Application No: BR/13/22/HH
Site Address: 235 Hawthorn Road Bognor Regis PO21 2UW
Description of works: Erection of two storey side extension and single storey rear orangery following the demolition of existing rear conservatory and side extension.

Thank you for your internet representation made on 16th February 2022 which has been recorded as an objection with the comments as follows:

GROUND FLOOR PLAN PROPOSED 1:50

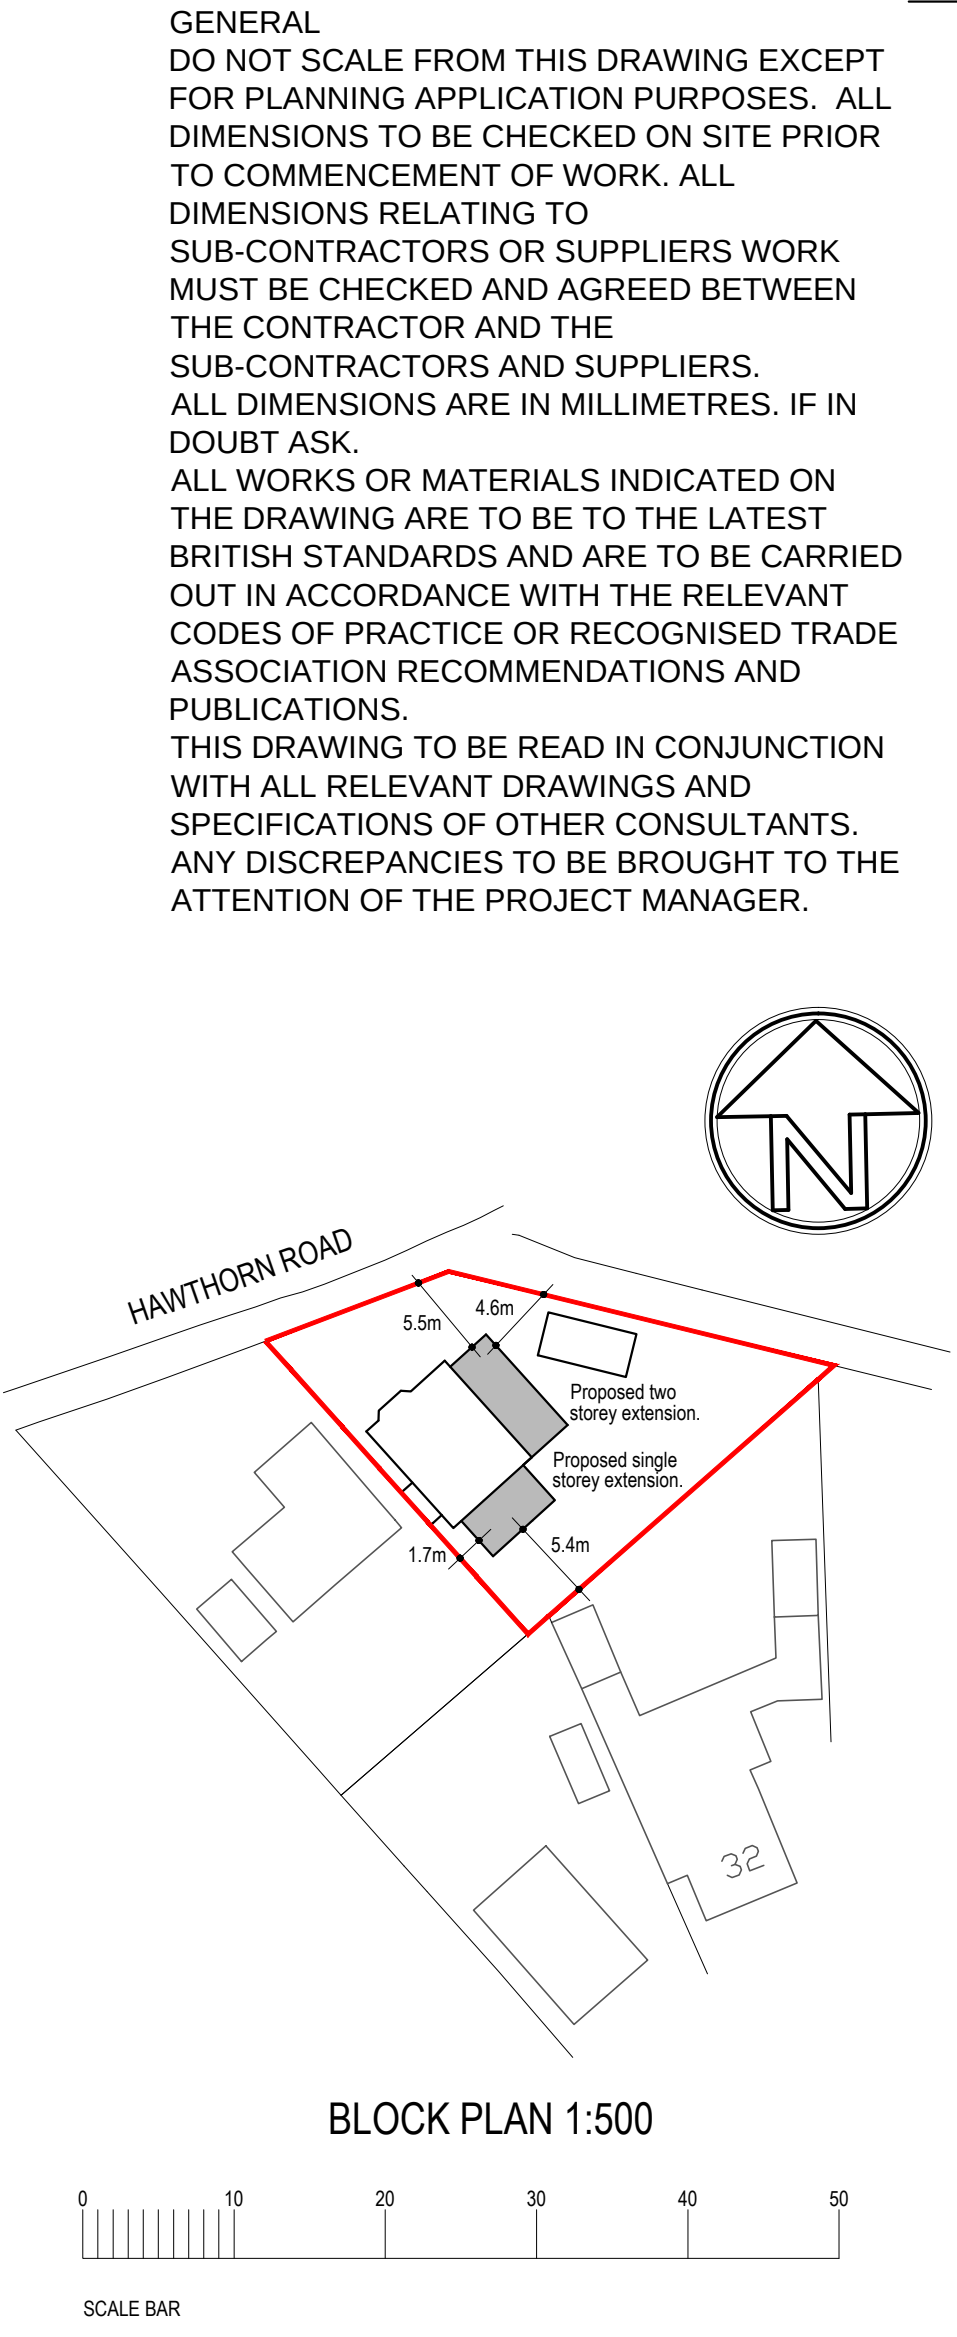
- 1) At present from our property, the first floor rear window at the rear is mostly obscured by our trees and shrubs. The three first floor side elevation windows have obscure glass so do not effect our privacy. The new side extension, however, would appear to be some one third the width of the existing property, bringing it closer to our boundary and although the middle window would probably have obscure glass fitted, the additional large first story window would not and would directly overlook our property, considerably reducing our privacy.
- 2) The height and width of the additional one third extension would result in our losing late afternoon sunshine in summertime.
